**WEST SUSSEX COUNTY COUNCIL
STRATEGIC PLANNING CONSULTATION**

SUBJECT: FG/45/15/PL - Change of use of land from agricultural/compost production to B8 storage. This application is a Departure from the Development Plan.

Hangleton Nursery, Hangleton Lane, Ferring, West Sussex, BN12 6PP

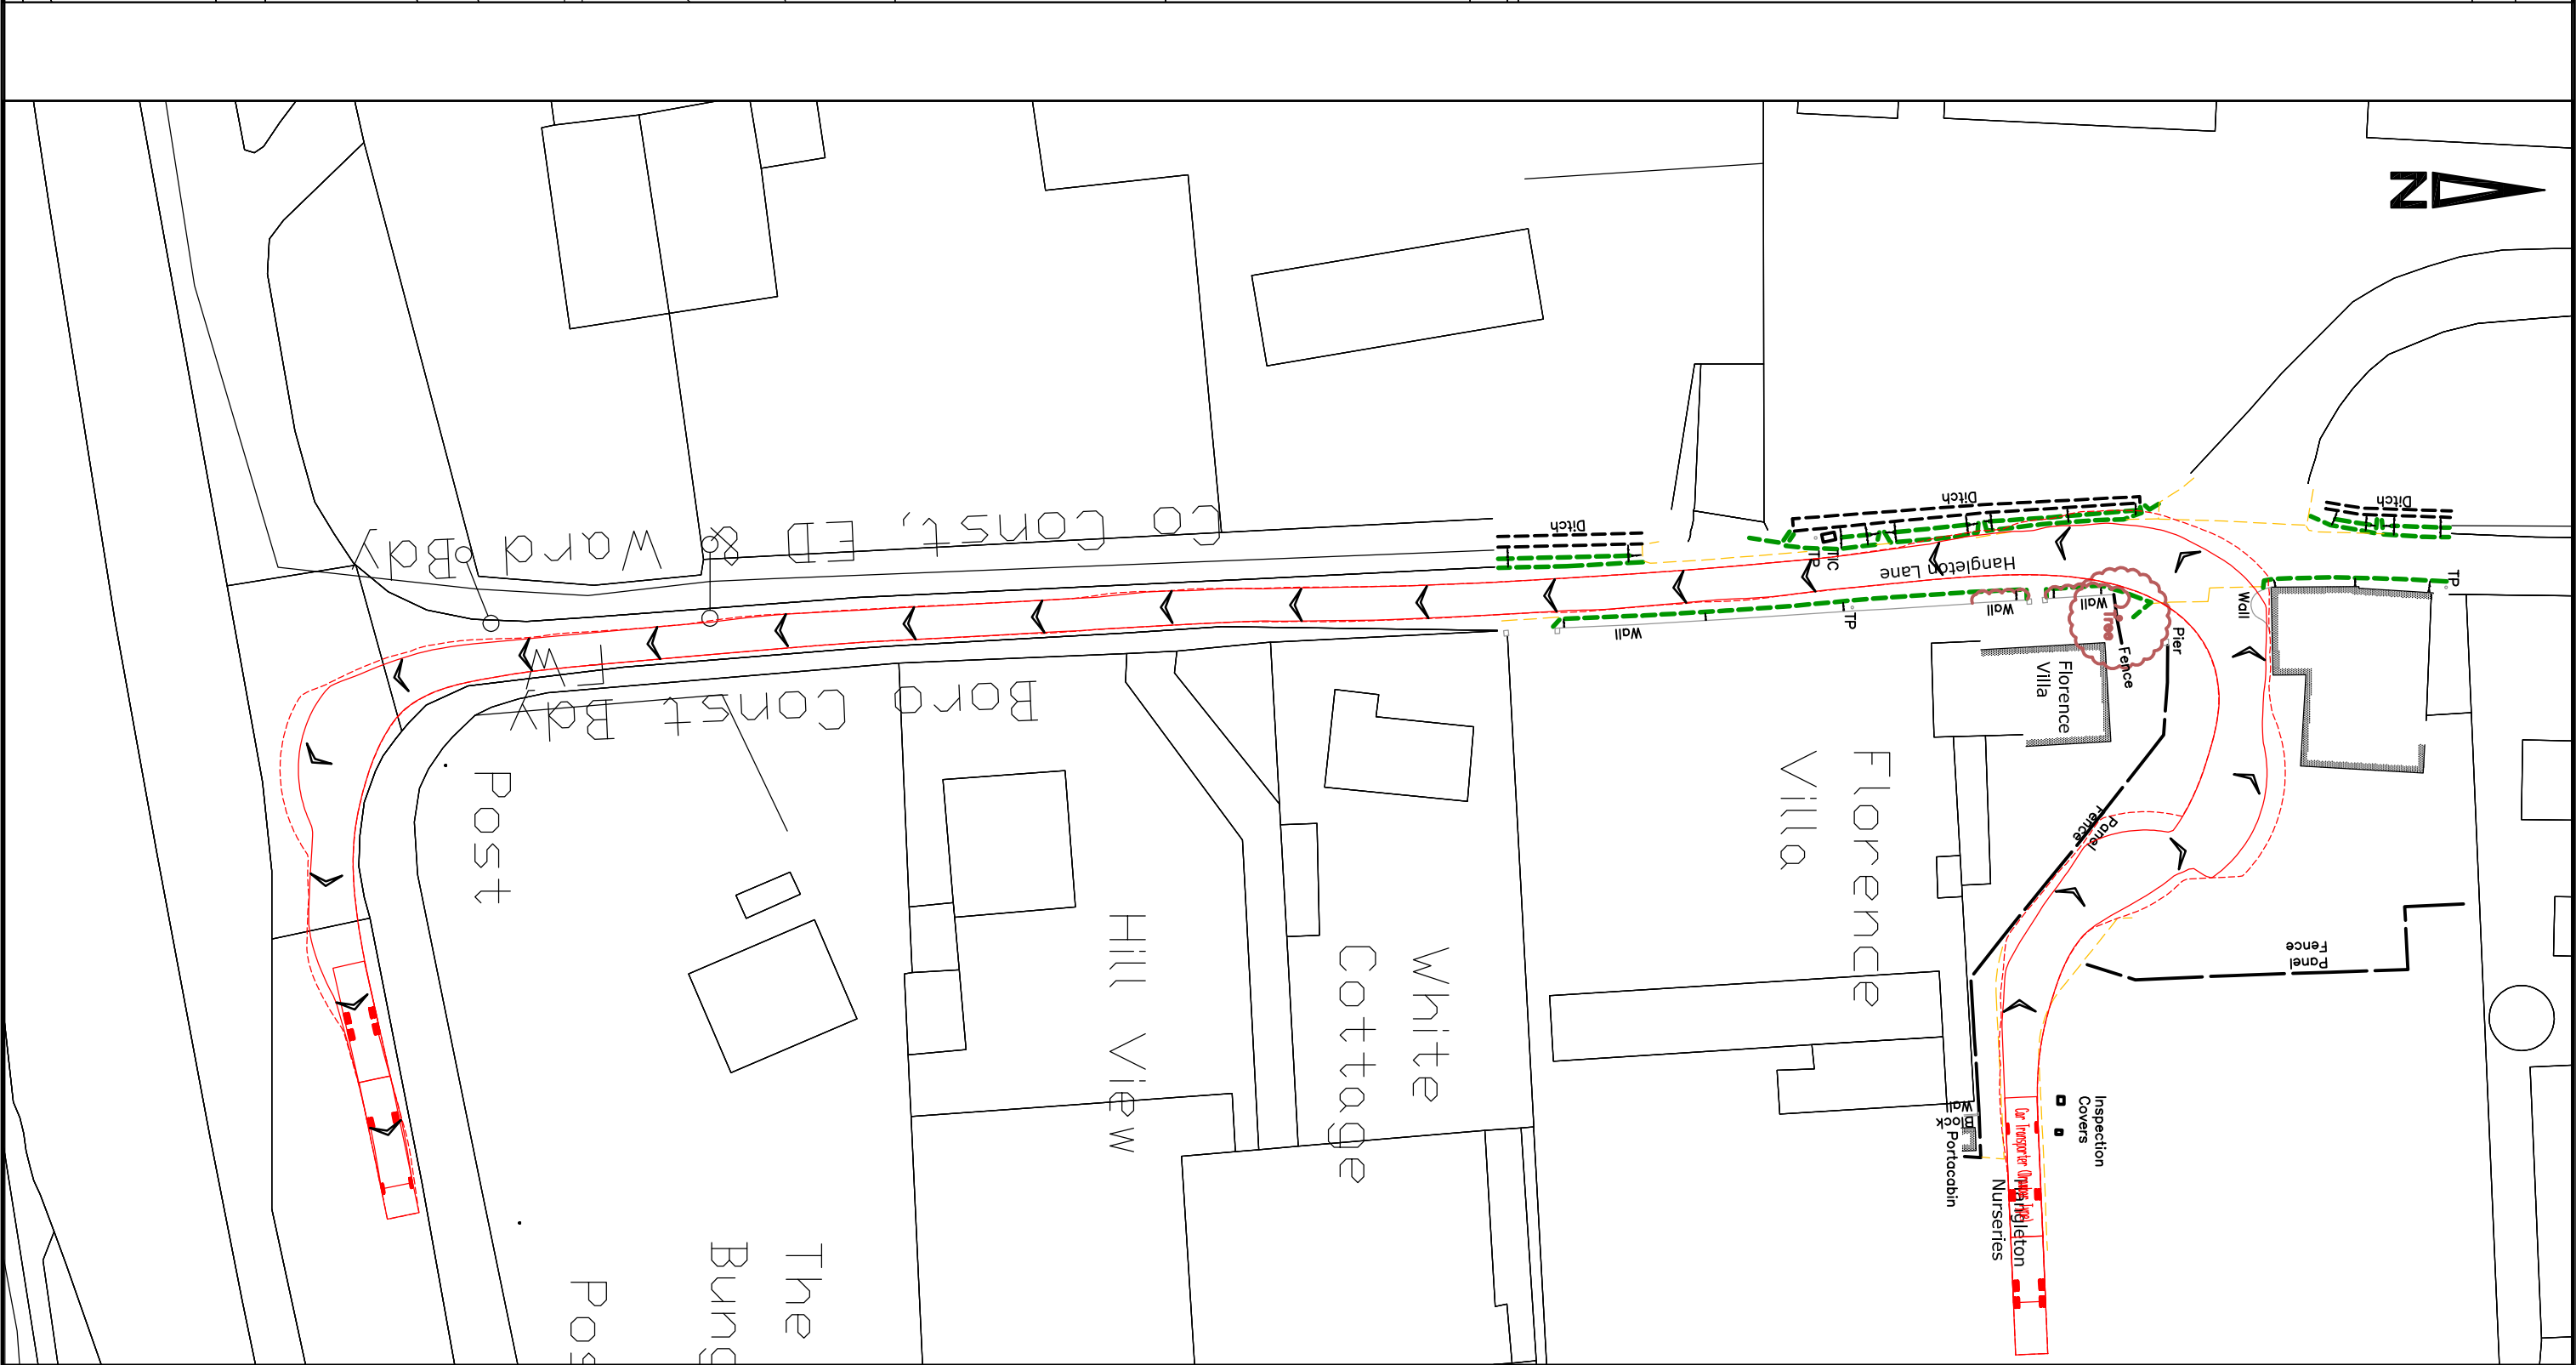
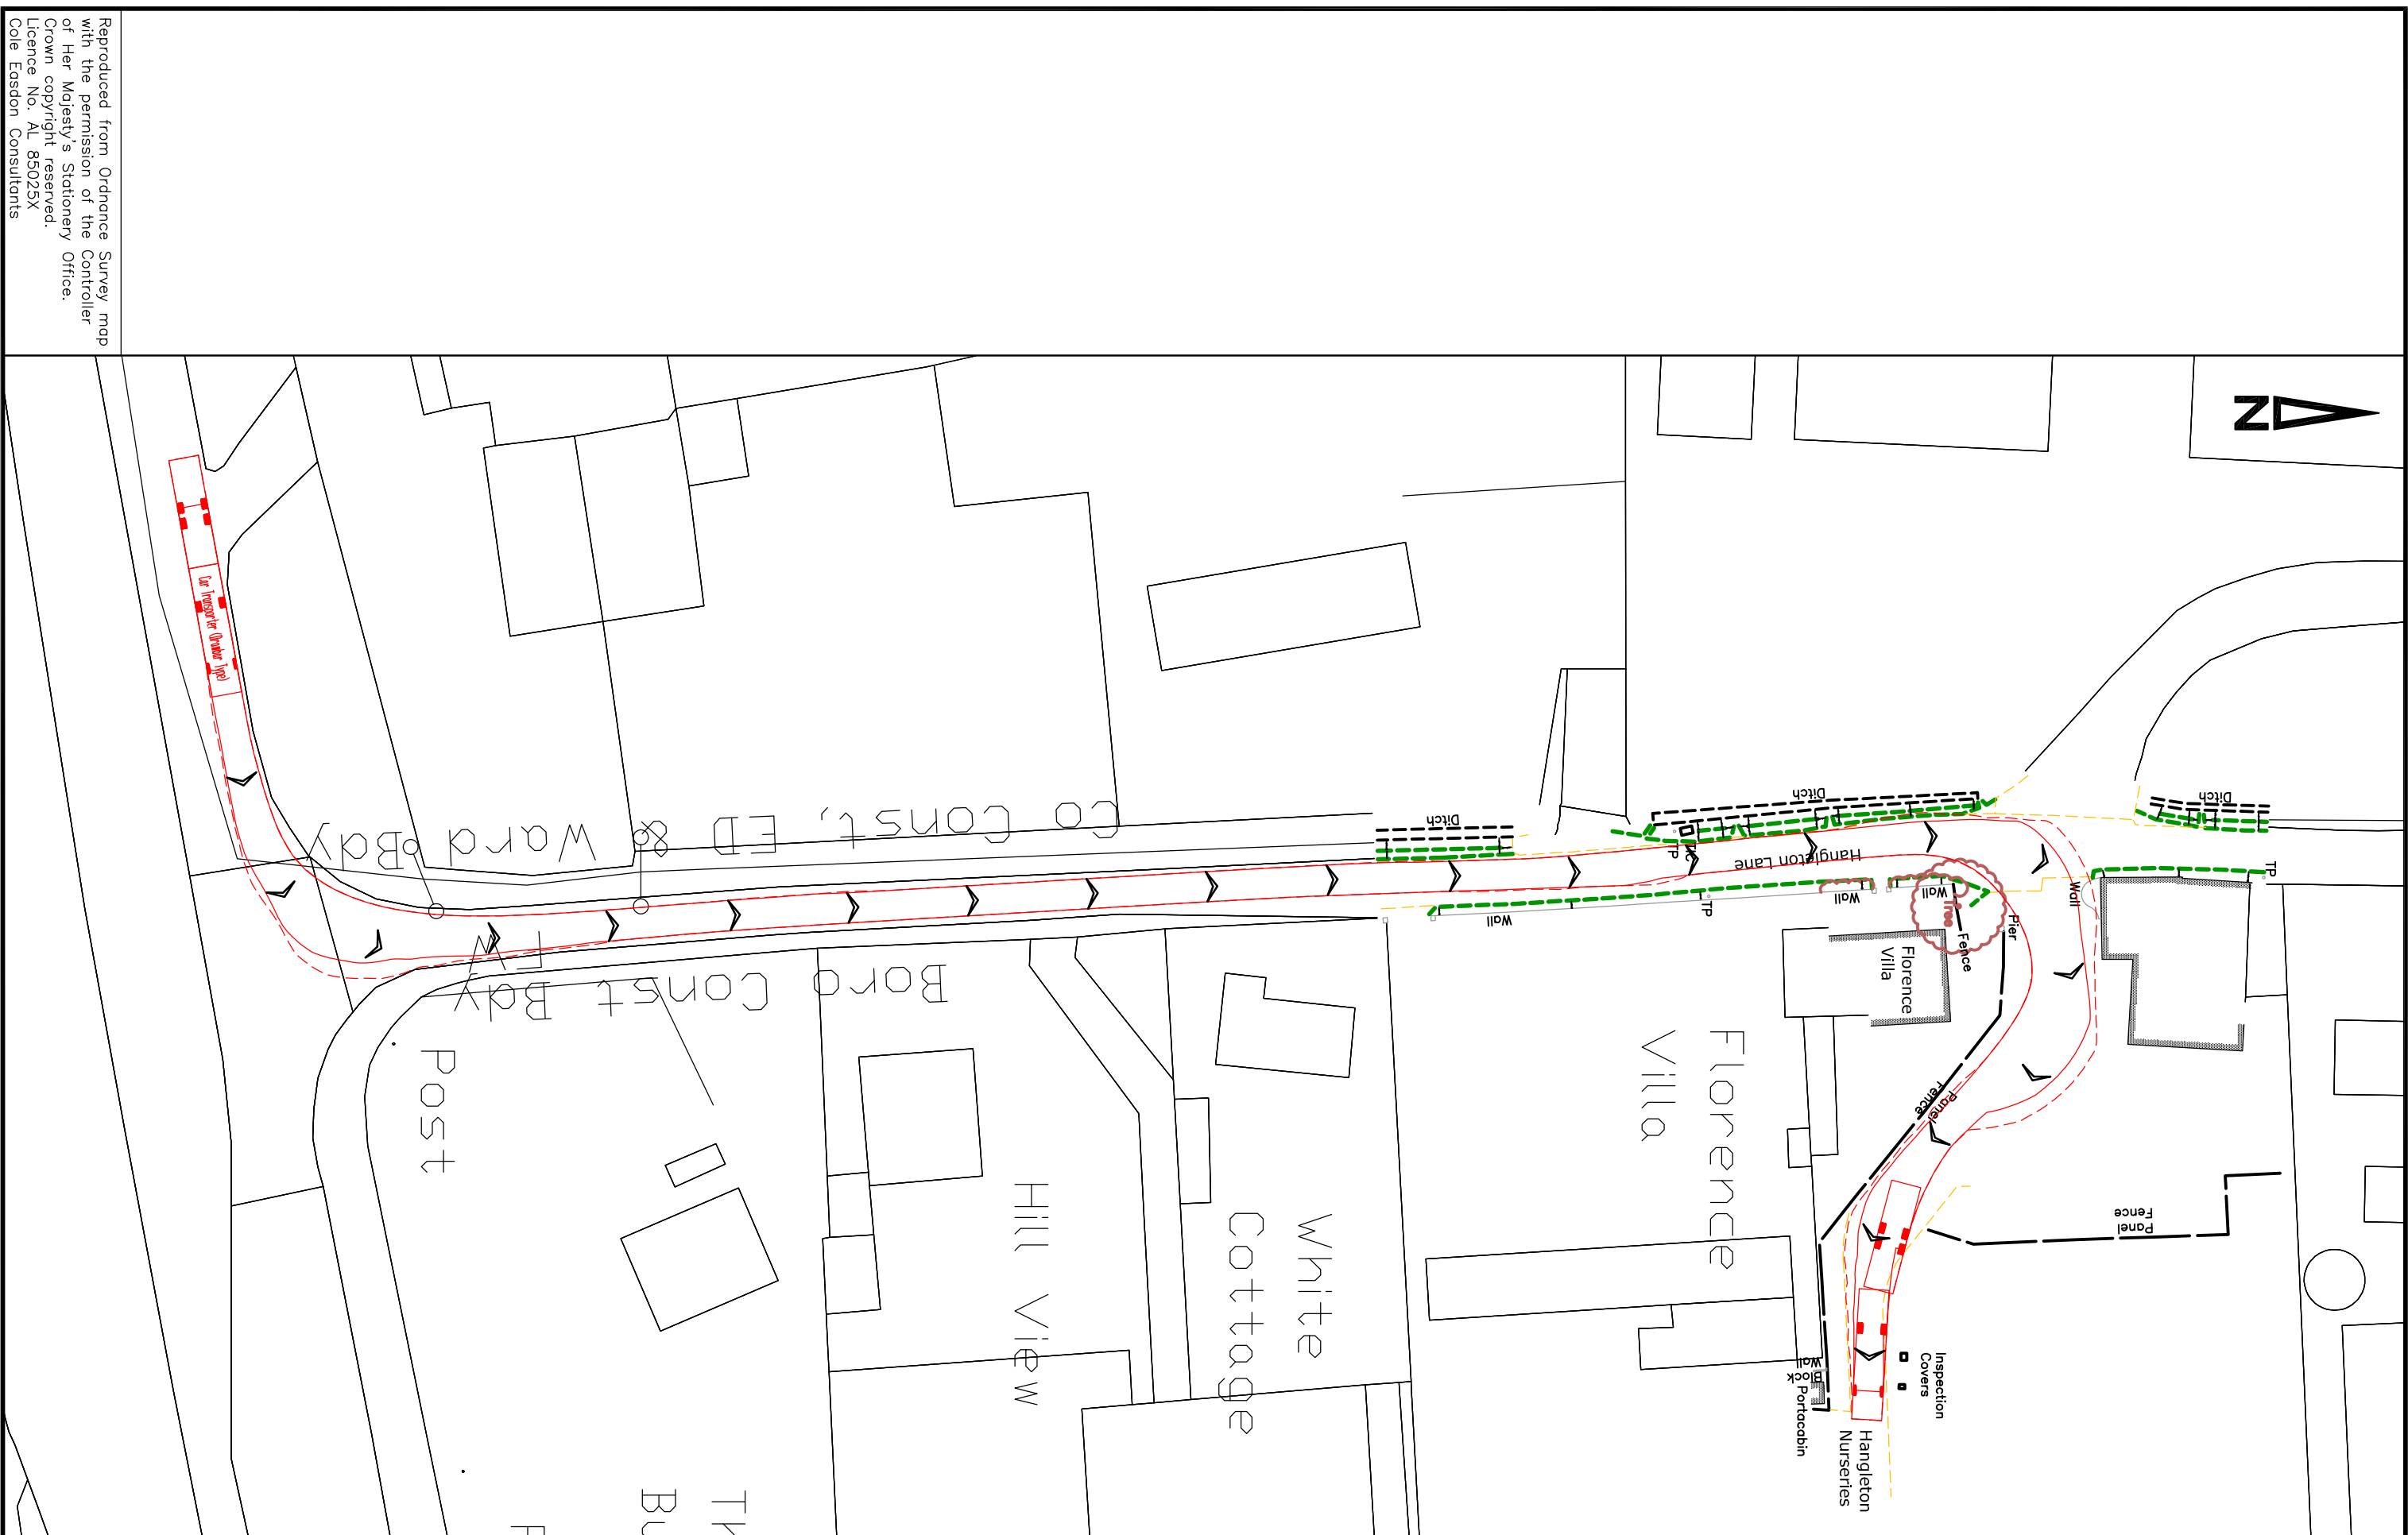
Swept path diagrams have been provided to show this vehicle can enter and exit the existing access in forward gear. WSCC acknowledge the swept path diagrams show encroachment into the second lane of the dual carriageway, on both entry and exit. However; immediately before the access is a Pegasus crossing and right hand turn into Langbury Lane which could aid the slowing of traffic, and equally provide longer windows of time for the transporter to exit safely. Visibility appears to be very good and clear although it is not known from the plans provided what current level of visibility can be achieved. It is considered that given the size of the vehicle there is an emphasis on all road users to use common sense and good judgement before entering the highway, or crossing the road.

As such WSCC do not raise objection to the proposal, but suggest that the LPA consider including a suitably worded condition placing a limit on the number, and type of movements made from this access.
